Final Report - Corrections Required **Application No. PDZL-24-0006**

Record Type : PDZ Land Use Plan

Document Filename : Southern Colorado Rail Park_LUP_V1_11-19-2024

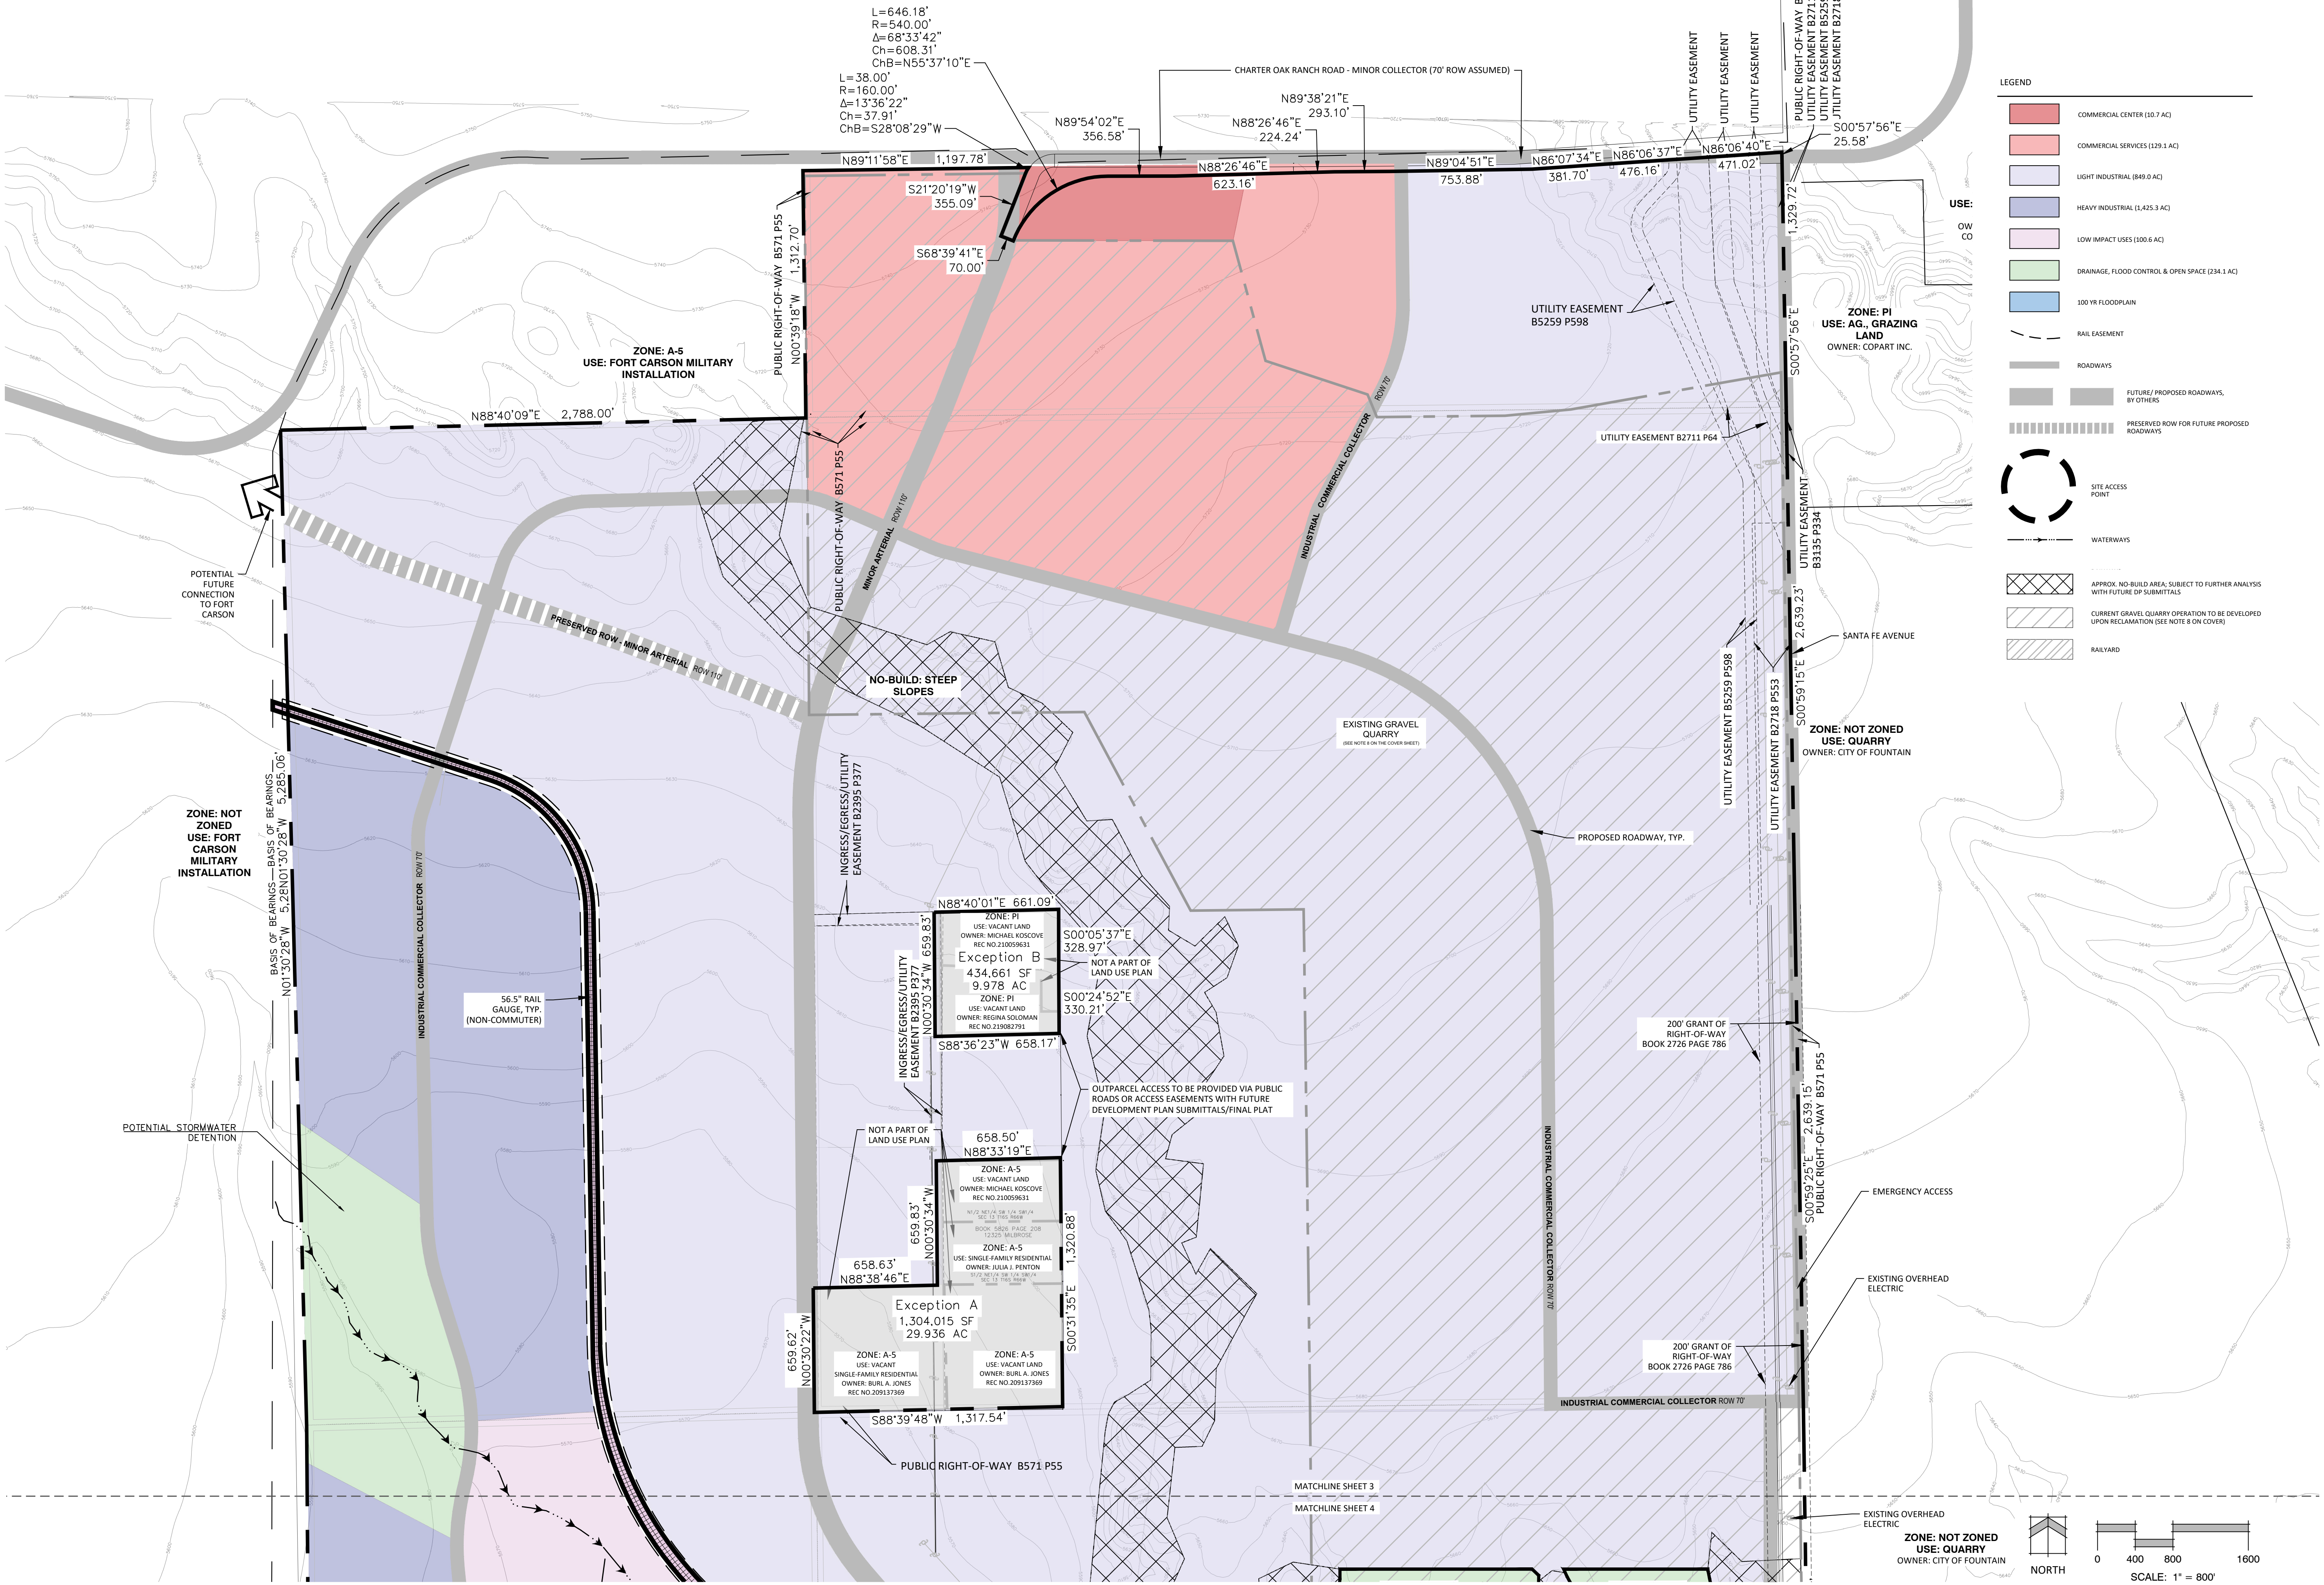
| Comment ID | Page Reference | Reviewer : Department | Review Comments |
|------------|----------------|----------------------------------------|-------------------------------------------------------------------------------------------------------------------------------------------------------------------------------------------------------------------------------------------------------------------------------------------------------------------------------------------------------------------------------------------------------------------------------------------------------------------------------------------------------------------------------------------------------------------------------------------------------------------------------------------------------------------------------------------------------------------|
| 18 | 2 | Sara Rivera : City Engineering - SWENT | Will the drainage, flood control & open spaces shown here be potential locations for proposed water quality and/or detention facilities? Please clarify as general locations need to be shown and labeled on the plans. |
| 22 | 2 | Sara Rivera : City Engineering - SWENT | Add a note stating that channel improvements will be installed with the site for all channels within the site and all channels downstream of the site, up to the highway. Include responsible party, long-term maintenance responsibility (private), and timing requirements (e.g. Channel improvements will be designed and constructed or assurances for channel improvements will be posted prior to building permit issuance for {developments}, and channel improvements must be constructed and accepted into probationary acceptance prior to CO release for {developments}. All channel improvements will be completed in accordance with current Drainage Criteria Manual and DBPS requirements). |

| Comment ID | Page Reference | Reviewer : Department | Review Comments |
|------------|----------------|----------------------------|--------------------------------------------------------------------------------------------------------------------------------------------------------------------------------------------------------------------------------------------------------------------------------------------------------------------------------------------------------------------------------------------------------------------------------------------------------------------------------------------------------------------------------------------------------------------------------------------------------------------------------------------------------|
| 21 | 2 | Cory Sharp : Planning | please check/revise the exterior boundary bearings, distances and curve information to match the legal description |
